Our Ref: R/2020/11/B
File No: 2020/523420
Your Ref: SSD-10454

Request for Advice - Intercontinental Hotel - Stage 2 (SSD-10454) – Response to Submissions

Figure 1 Wall mounted bicycle parking layout

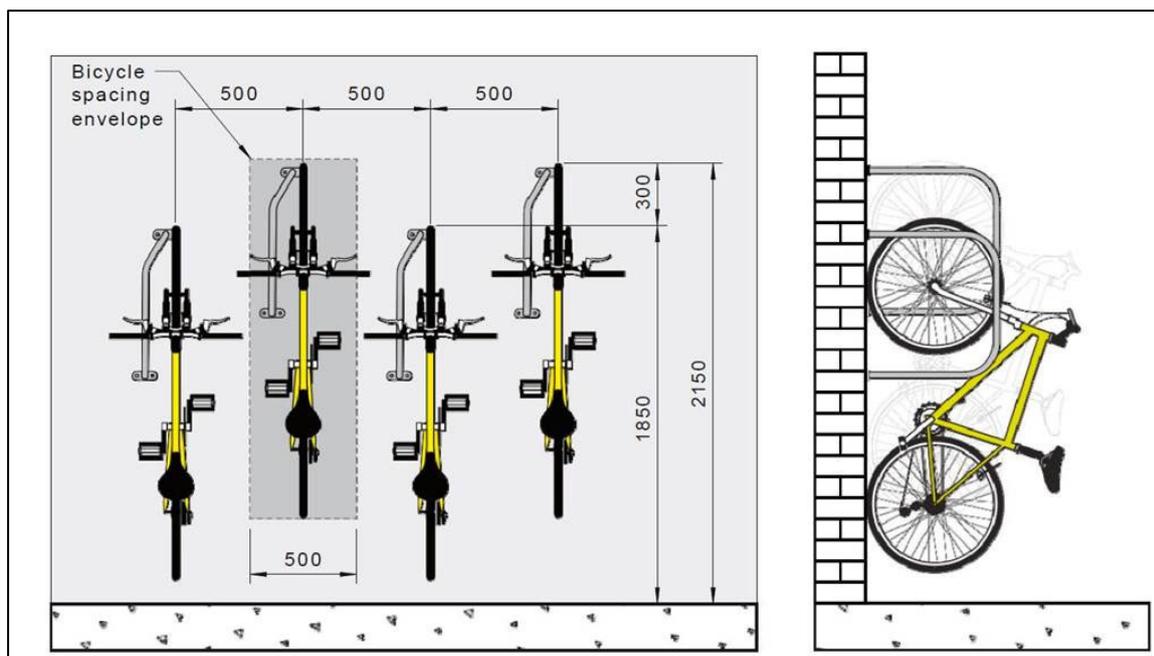
In the City's previous correspondence, it was recommended that at minimum, the proposal accommodate bicycle parking facilities reflecting the projected staff member increase on site, being 18 bicycle parking spaces in total. The applicant has stated in their RtS that due to current security and basement planning constraints, the development can only accommodate a total of 15 bicycle parking spaces, being a threefold increase from the existing facilities on site. Further, the RtS states the increase in bicycle parking to a total of 15 spaces is consistent with Council's overall objectives of increasing the availability of bicycle parking on site.

This argument is accepted by the City noting that there is further opportunity to provide bicycle parking spaces and end of trip facilities as part of the ballroom addition works. Any separate proposal for the ballroom addition must provide bicycle spaces and EOT facilities catering for the expected visitors and total staff, not just projected additional visitors and staff.
